**Response to Department of Planning and Environment Request for
Further Information for SSD 6746 MOD 1 – UTS Blackfriars Precinct
Research Building**

SSD 6746 MOD 1 - UTS Blackfriars Precinct Research Building
Schedule 1: Requested Information

Drawing Title
UTS BLACKFRIARS CAMPUS CB23
**A22 - 3D VIEW - FROM NOTRE
DAME COURTYARD LOOKING
WEST**

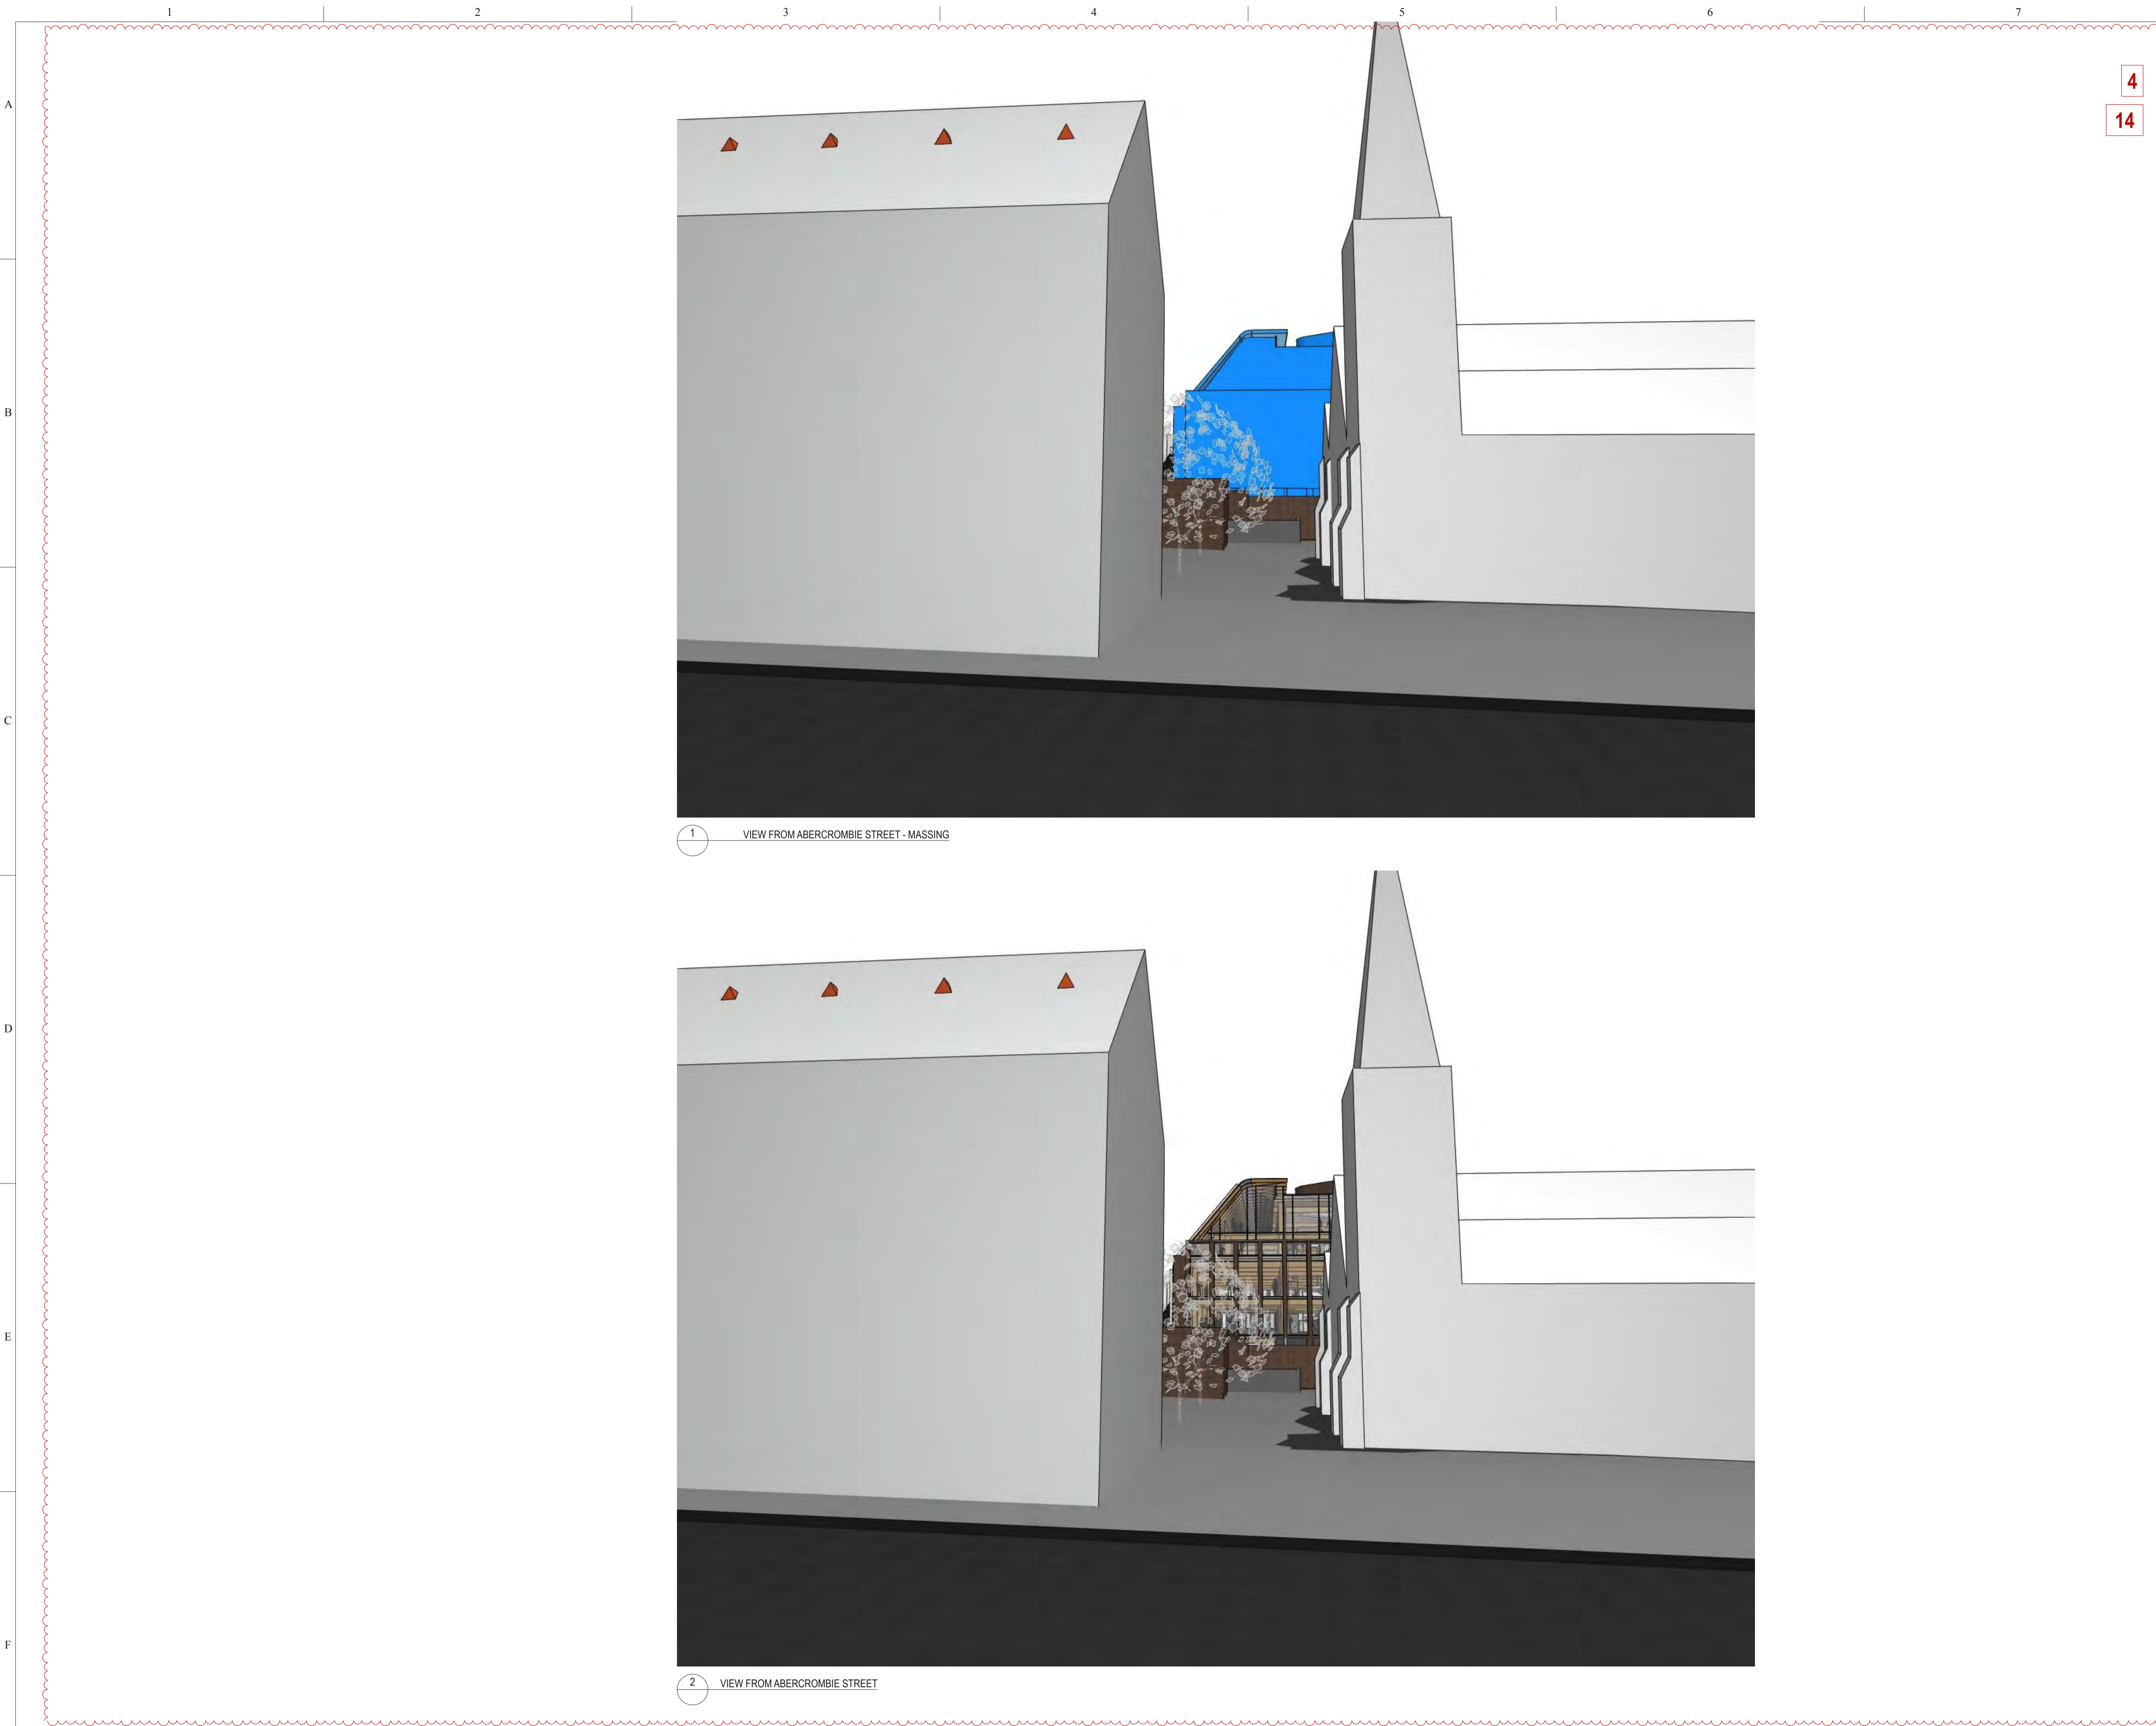
Requested Information	Where the information is located, and relevant comments
<p>4. Provide 3D images of the proposed building envelope in the context of the site and surrounding buildings, including the southern elevation, Buckland Street views and the view from University of Notre Dame courtyard.</p>	<p>3D images are provided in the following new drawings:</p> <ul style="list-style-type: none"> • A19: 3D VIEW - BUCKLAND ST LOOKING EAST • A20: 3D VIEW - GRAFTON ST LOOKING EAST • A21: 3D VIEW - SOUTHERN ELEVATION PUBLIC DOMAIN VIEW • A22: 3D VIEW - FROM NOTRE DAME COURTYARD LOOKING WEST • A23: 3D VIEW - FROM ABERCROMBIE STREET • A24: 3D VIEW - BROADWAY LOOKING SOUTH-WEST <p>Revised Architectural Drawings including 3D images addressing the requested information are at Attachment A.</p>
<p>Setbacks</p>	
<p>5. Identify on plan the southern setback of the sloped facade/ roof to the existing buildings on the site.</p>	<p>The setback is identified on drawing A02 - PROPOSED BUILDING ENVELOPE PLAN and is 7900mm to the former boys school CB25 and is 16700 to the former girls school CB22.</p>

Drawing Title UTS BLACKFRIARS CAMPUS CB23 A09 - ST BENEDICT'S COURTYARD SHADOW STUDY		
FMU Project Number 03013-C-18		
Drawn By SB, JH, JB, KP	Checked RS, KL	Approved By TG

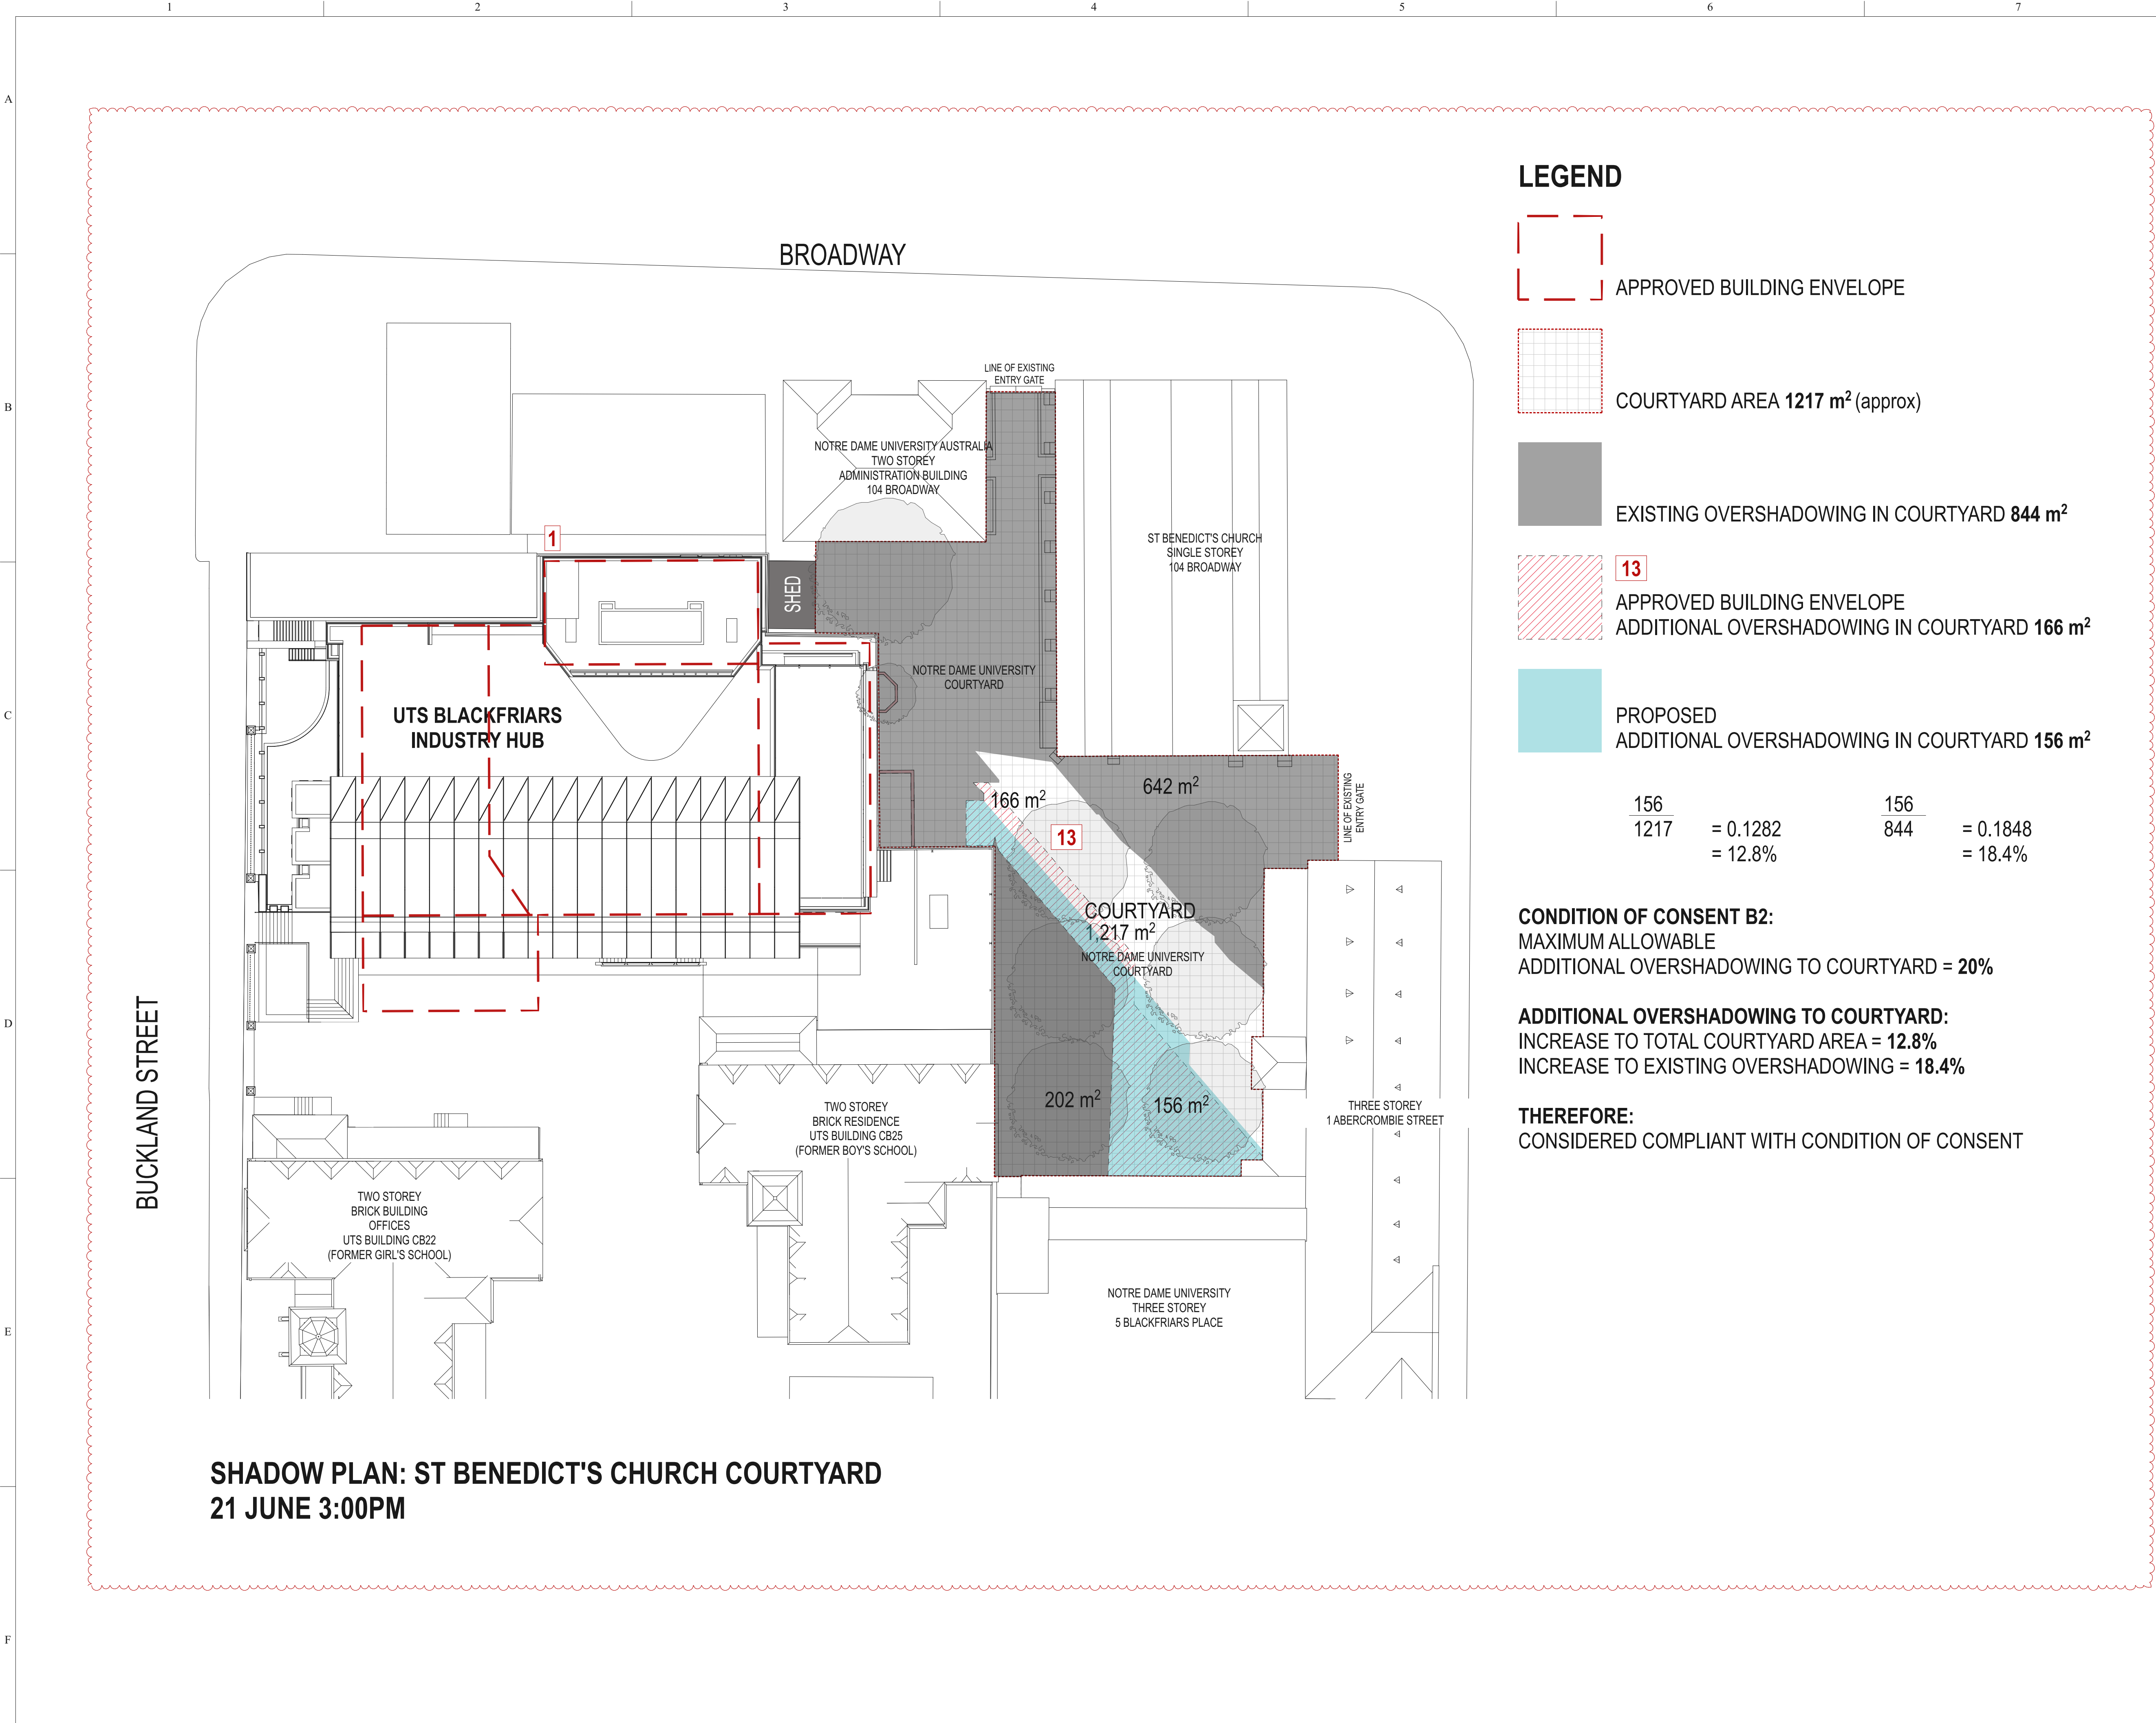
<p>13. Provide a shadow diagram at 3pm, June 21, of the University of Notre Dame courtyard, comparing the impact from the eastern edge height of the approved concept plan (as modified by the conditions of consent) and the proposed modification.</p>	<p>A shadow diagram at 3pm June 21 for the UNDA courtyard comparing the impact from the eastern edge height of the approved concept plan (as modified by the conditions of consent) and the proposed modification is provided at Drawing A09 ST BENEDICT'S COURTYARD SHADOW STUDY (see attachment A). The study shows the proposed modification reduces the amount of shadow compared to the approved envelope by 10m² and that the overall additional shadow at 18.4% is less than the maximum 20% additional shadow permitted by condition B2.</p>
